In reply please quote: 10102884
Your Ref: MP08_0066 MOD 4

14 September 2012

**MODIFICATION REQUEST FOR OAKDALE INDUSTRIAL ESTATE, SITE 1A
(MP08_0066 MOD 4)**

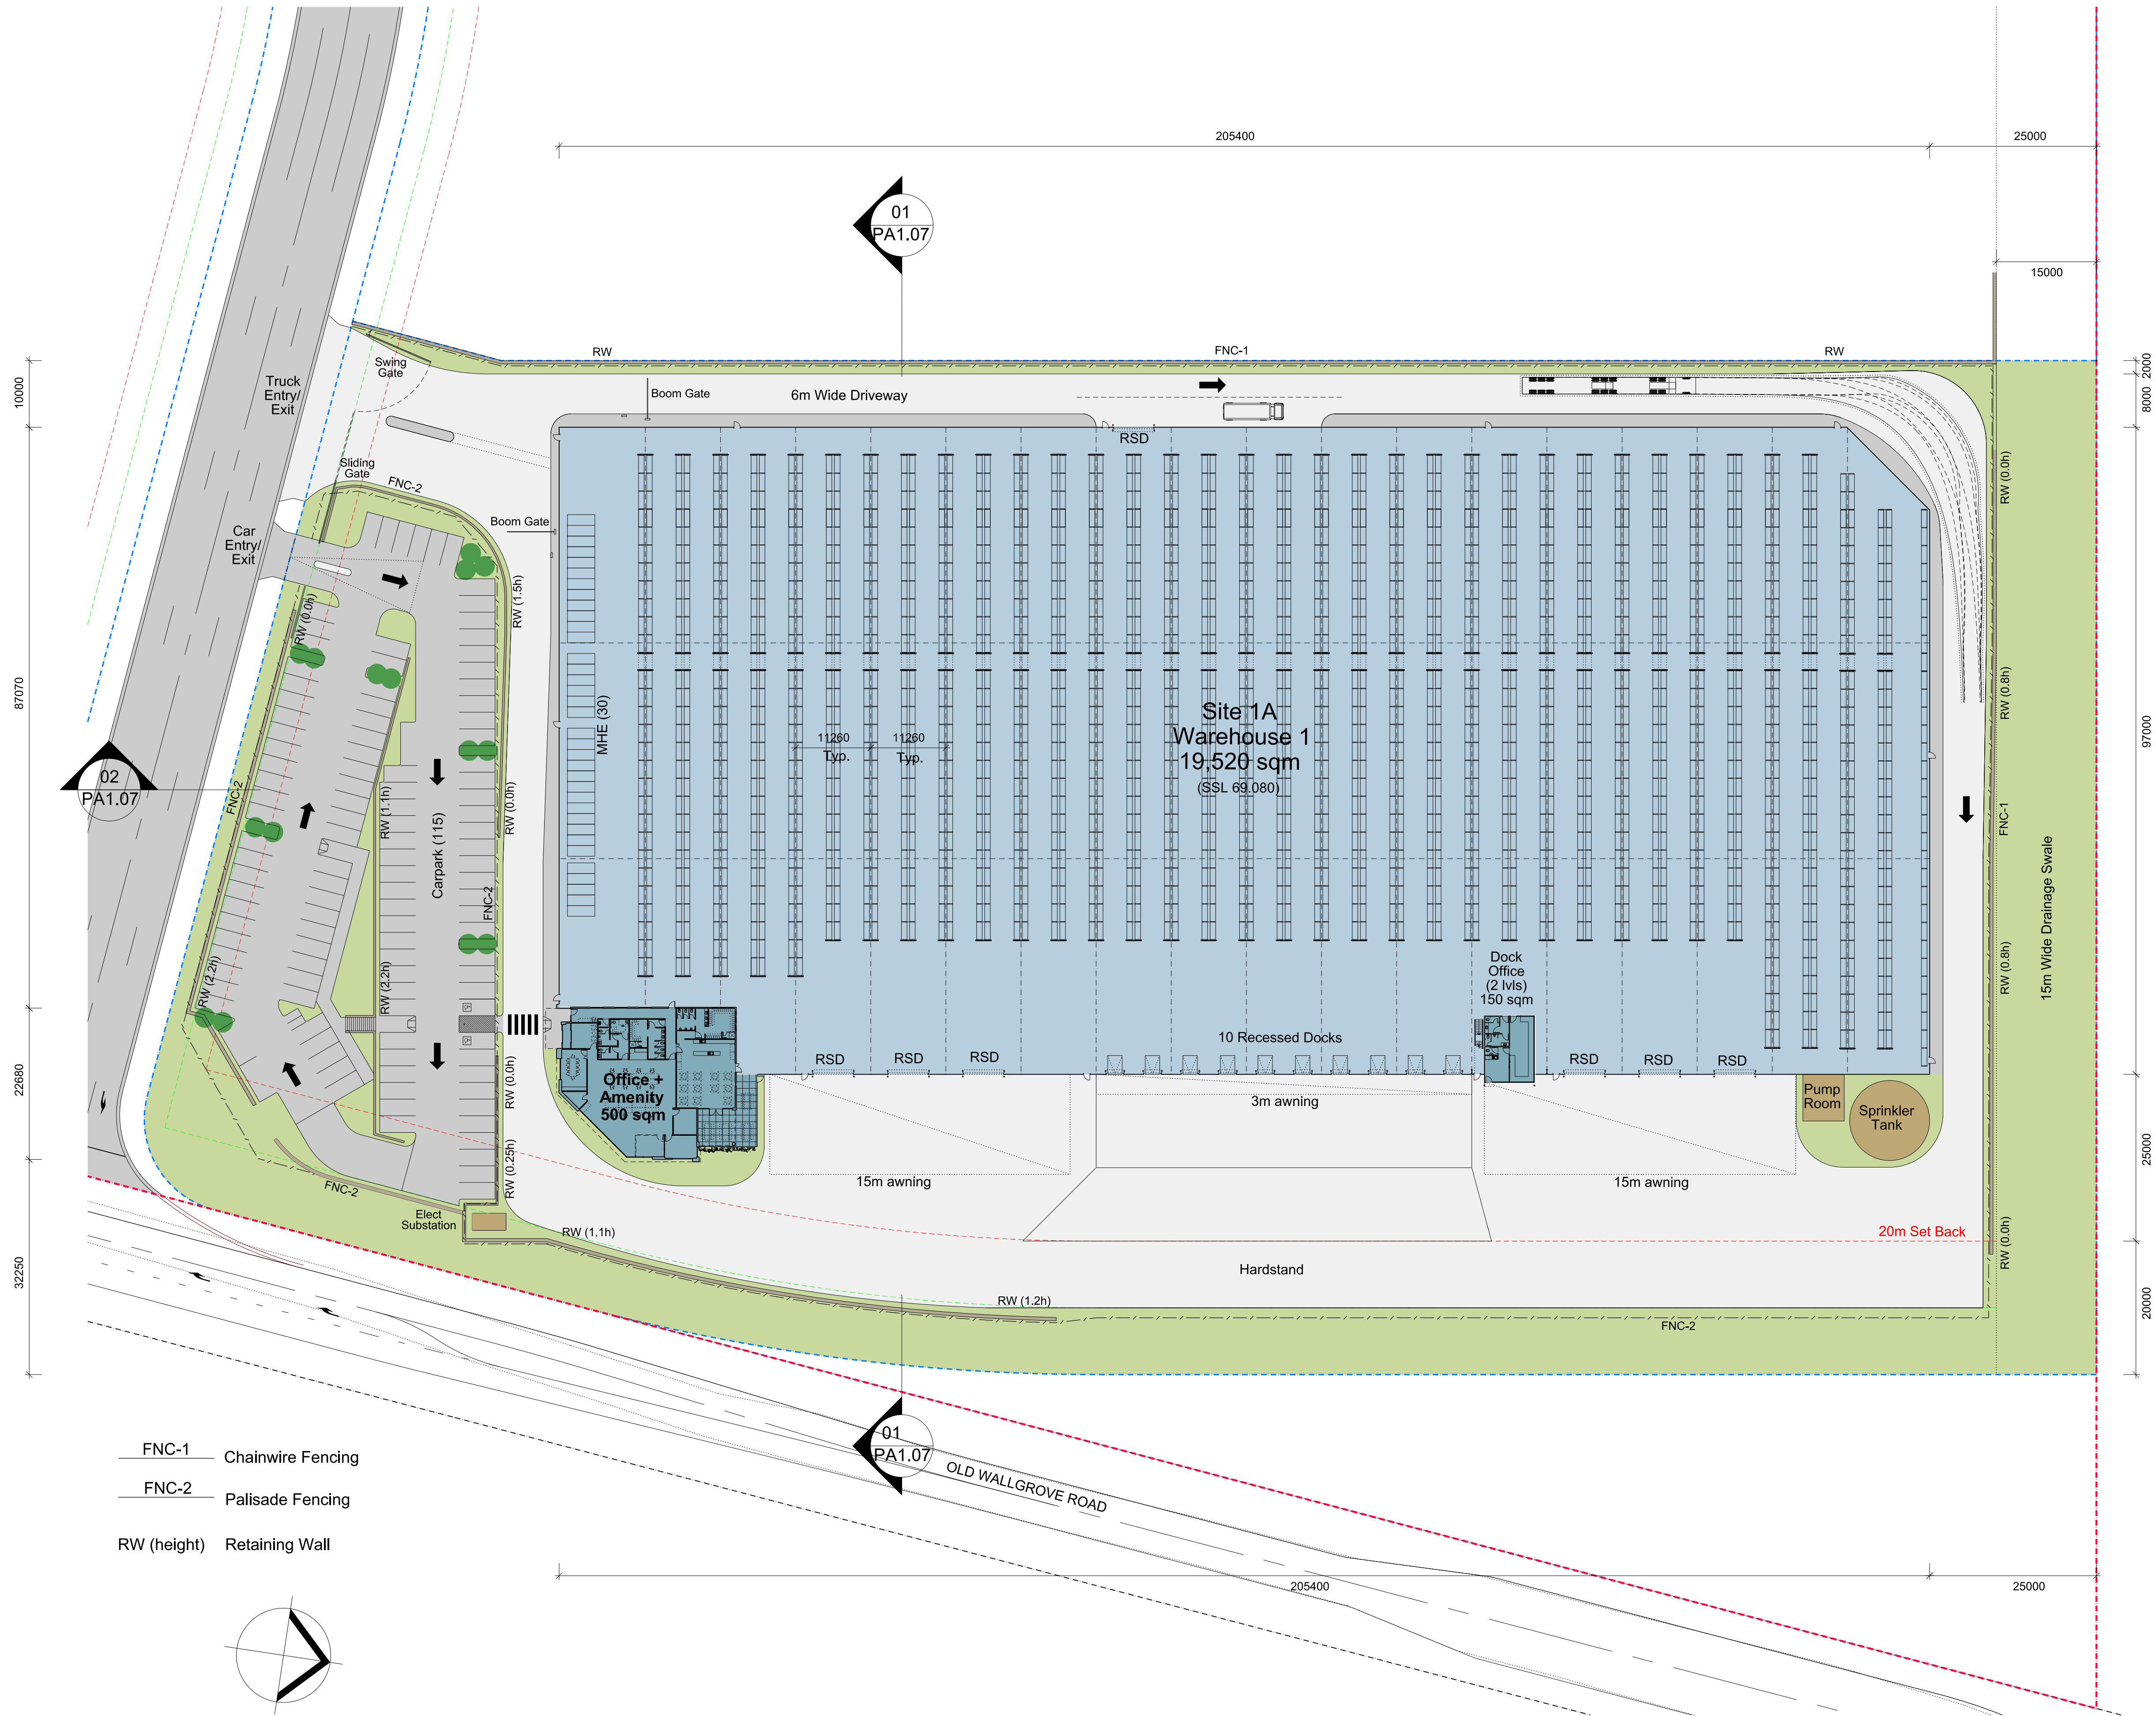
The proposed reduction of car parking spaces for the development shall be adequately justified, given that the proposed number of car parking spaces for the development is a departure from Fairfield City Wide development Control Plan 2006 and the location of the site away from public transport.
